Applicant's Response to Barnsley Metropolitan Borough Council Highways Comments

Barnsley Metropolitan Borough Council Applications Reference: 2023/0753

Land to the east of Sheffield Road, Hoyland Common, Barnsley

15 September 2023

Drawing: Visibility Splay Analysis

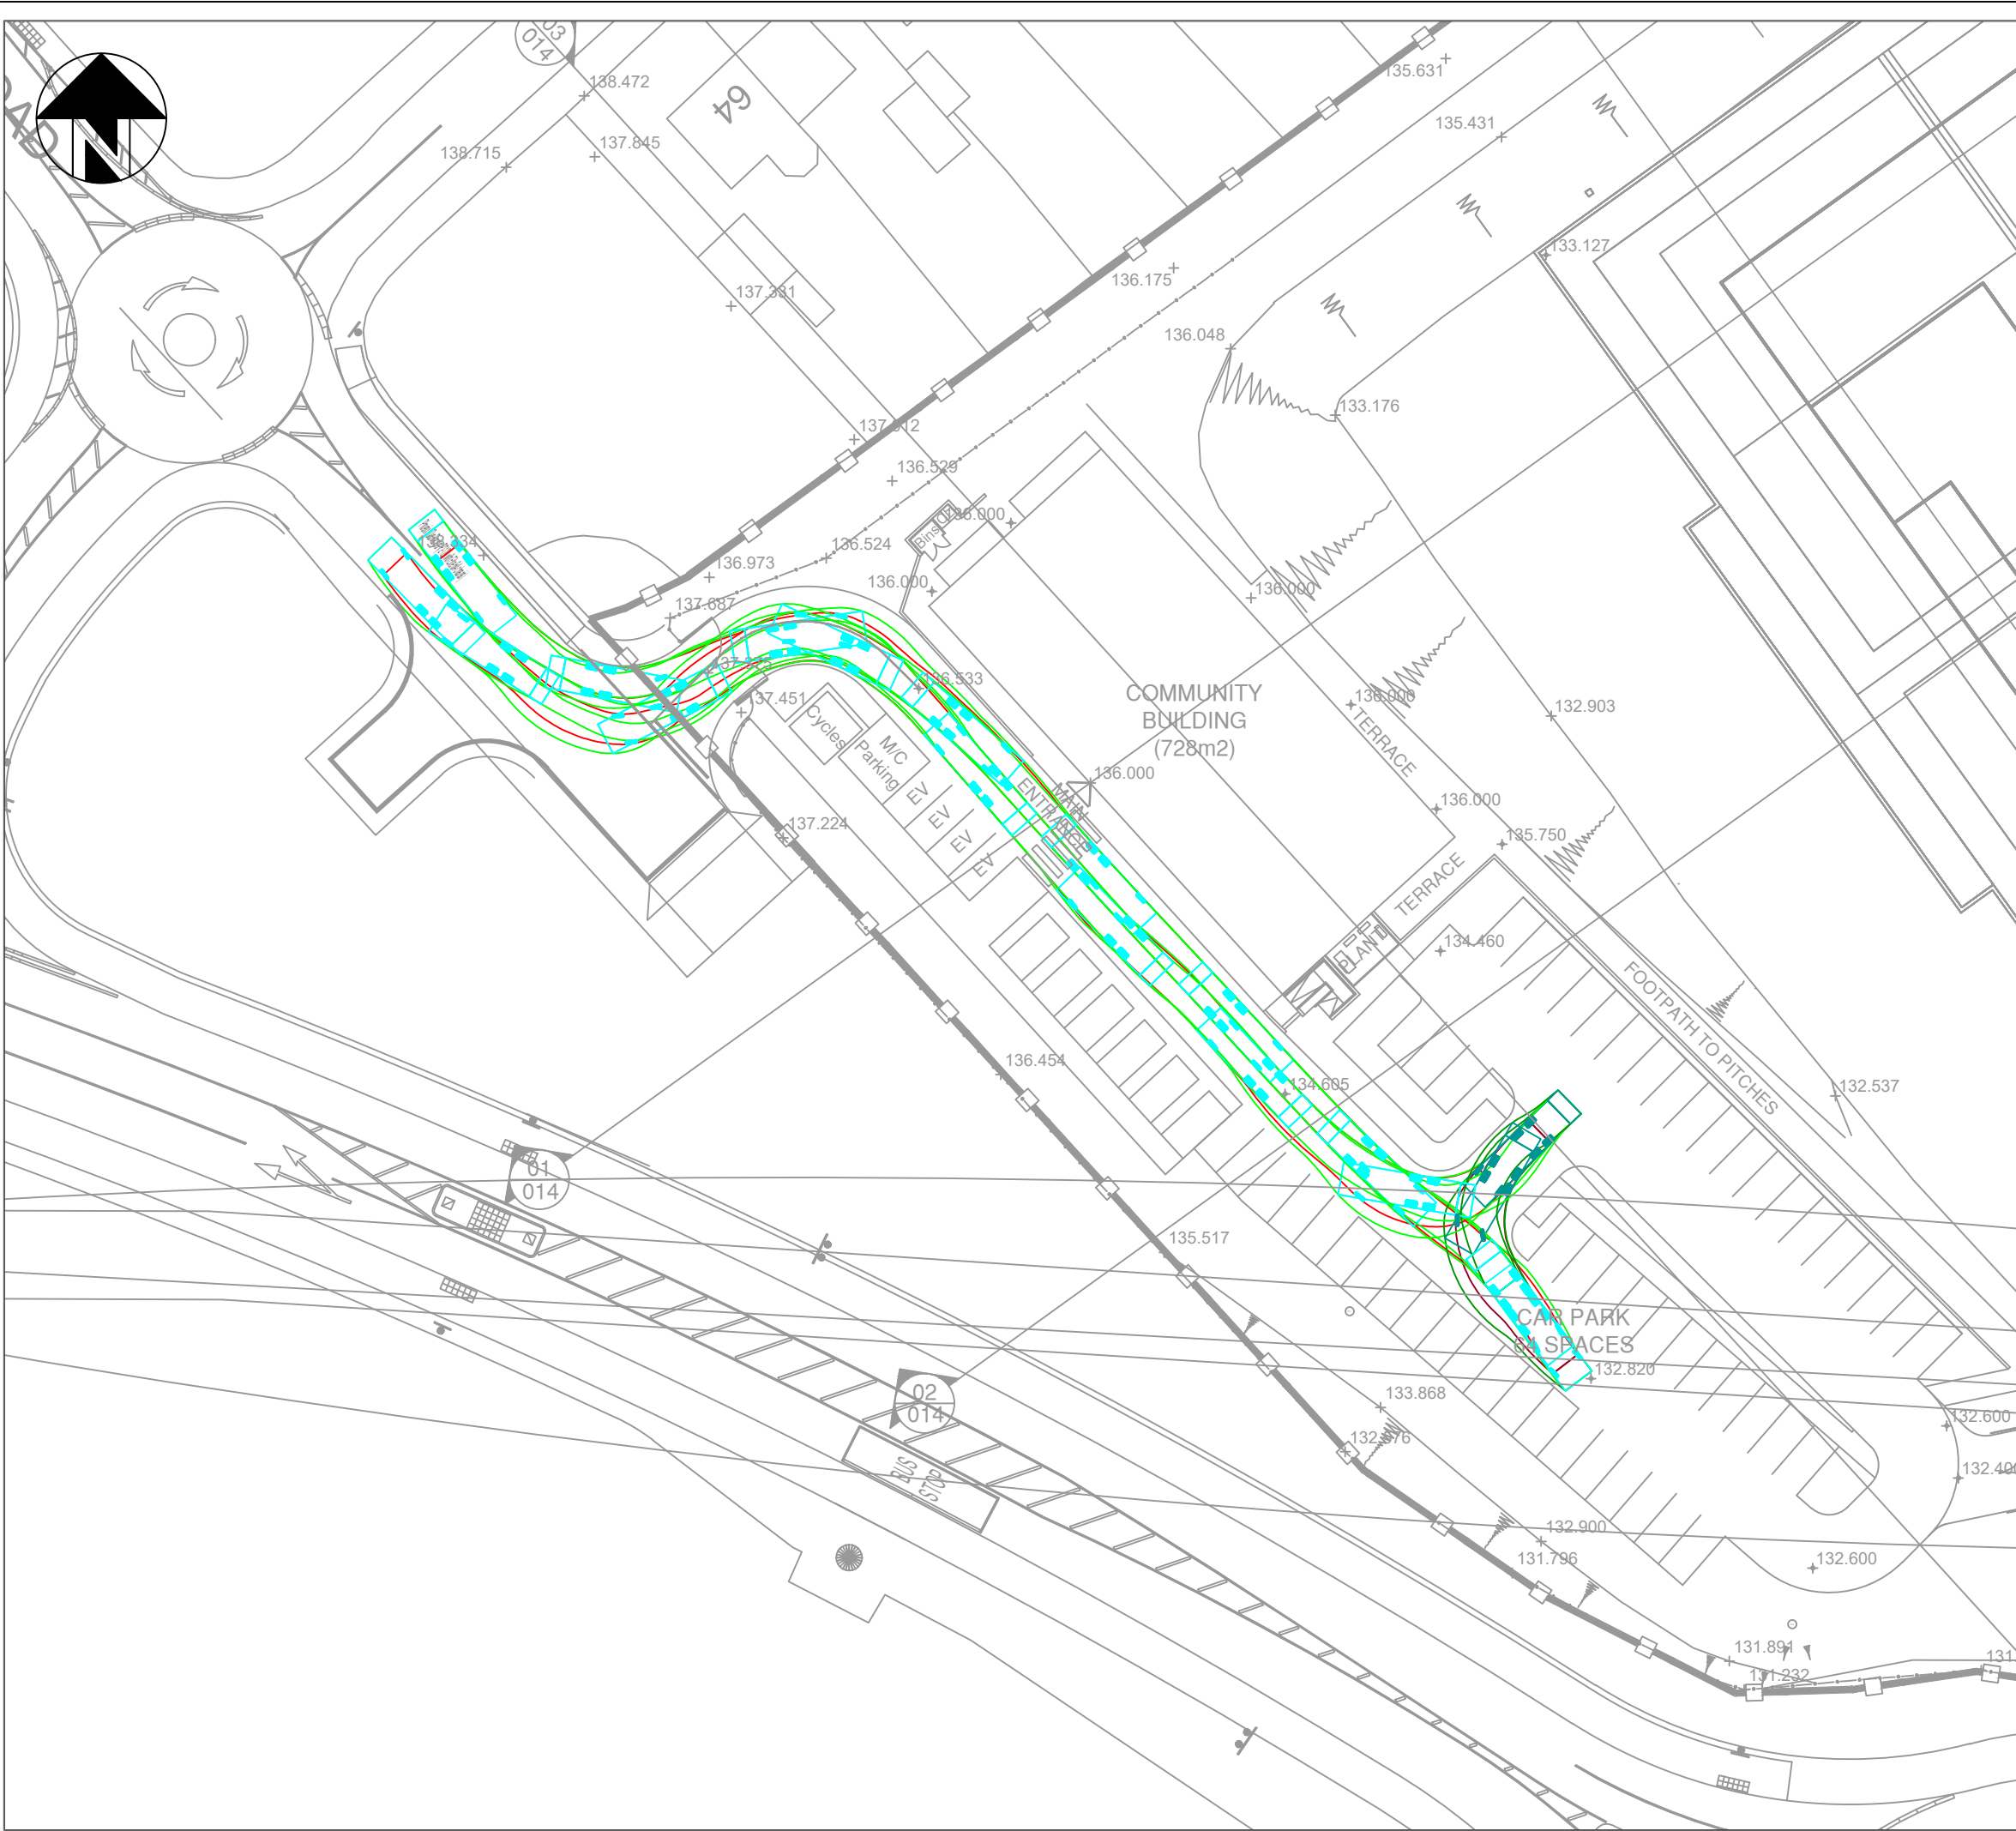
The submitted layout drawing shows the access having a width of 6.0m. However, the built access presently only measures 5.6m in width. As such, amendments to the existing junction will be required for the scheme to be constructed as per the submitted layout.

The proposed pedestrian route into the facilities anticipates that foot traffic using Sheffield Road will cross the access to enter the site. To the north-west of the site, the spur off the roundabout benefits from dropped kerbs and tactile paving to provide a high specification crossing point. Highways DC officers would expect the same standard of crossing facility across the site access to be included in the scheme.

- Dropped kerb and tactile paving added to the site entrance to assist pedestrian movement.
- An independent survey of a comparable, nearby sports/community facility to ascertain likely weekend parking numbers.

The width of the proposed access has been narrowed to match the access which has already been constructed at the site. In addition, an uncontrolled dropped kerb crossing with tactile paving has been incorporated into the access design. The updated access drawing is included at **Appendix B**.
